6 September 2021

**SSD 9726 – ADAPTIVE REUSE OF THE ROYAL HALL OF INDUSTRIES
CONDITION B34 – HERITAGE INTERPRETATION
CONDITION B38 – HERITAGE – MINIMISING IMPACTS**

3 RHI NORTH ELEVATION - EWG-N0-X02
1:50

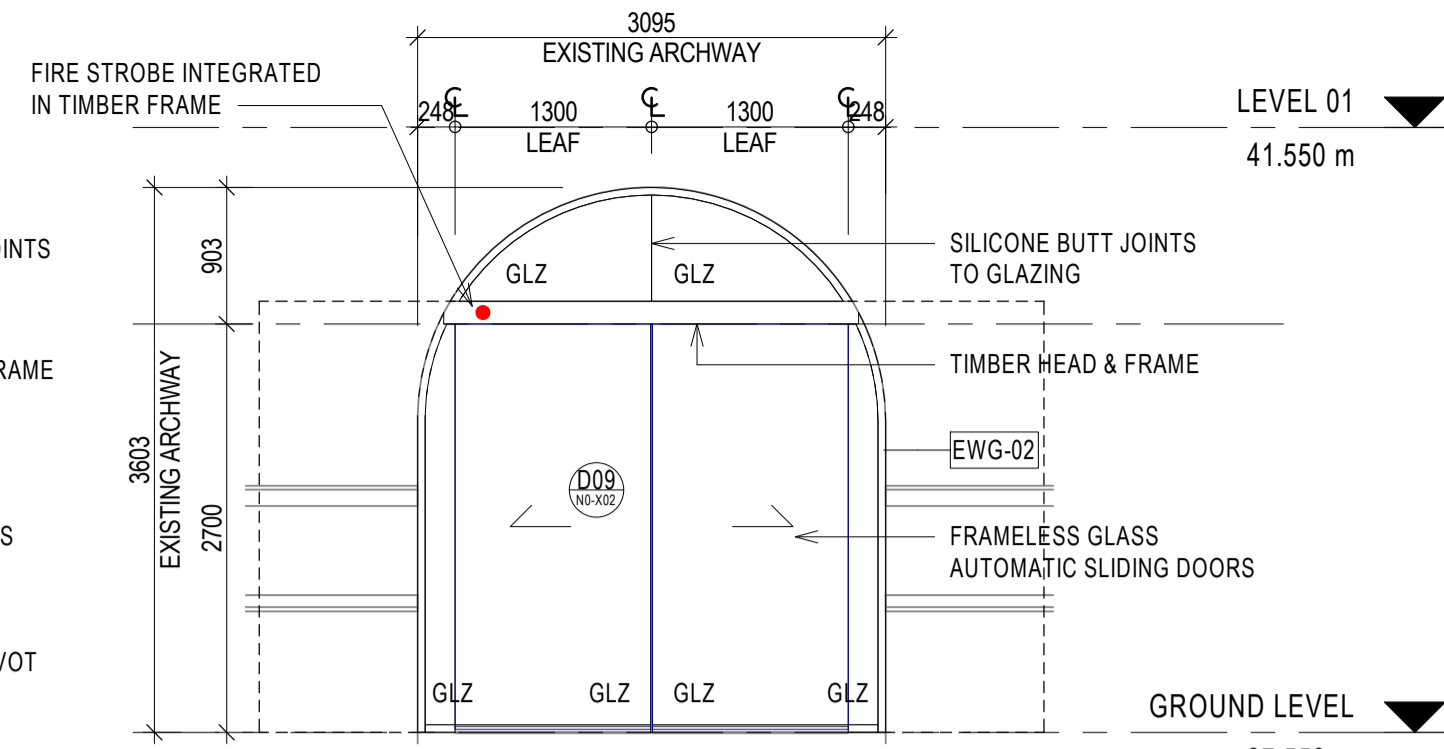
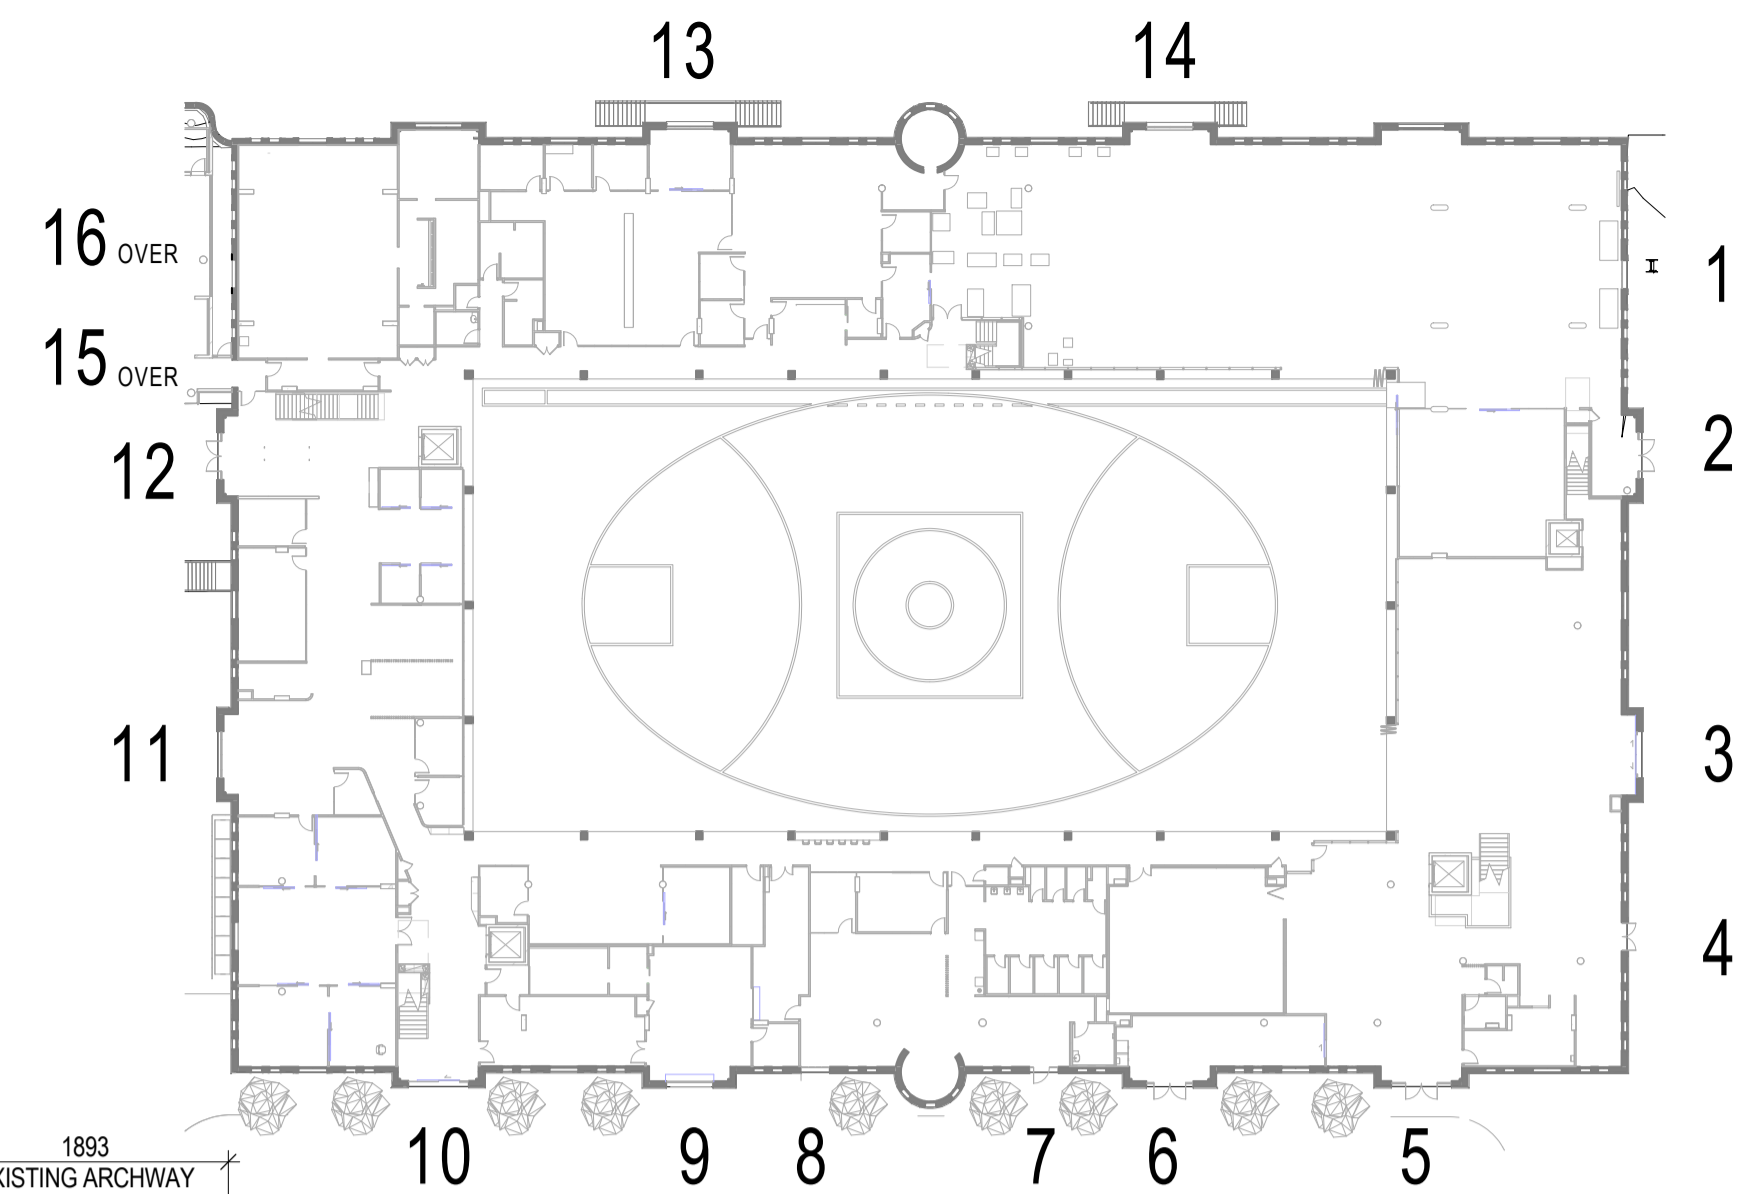
The submitted letter by Populous, dated 23 July 2021, and elevations and window details prepared by Populous, satisfactorily demonstrate how heritage impacts to existing windows and doorways will be minimised. Evidence of endorsement of this strategy by Heritage NSW is required by this condition.
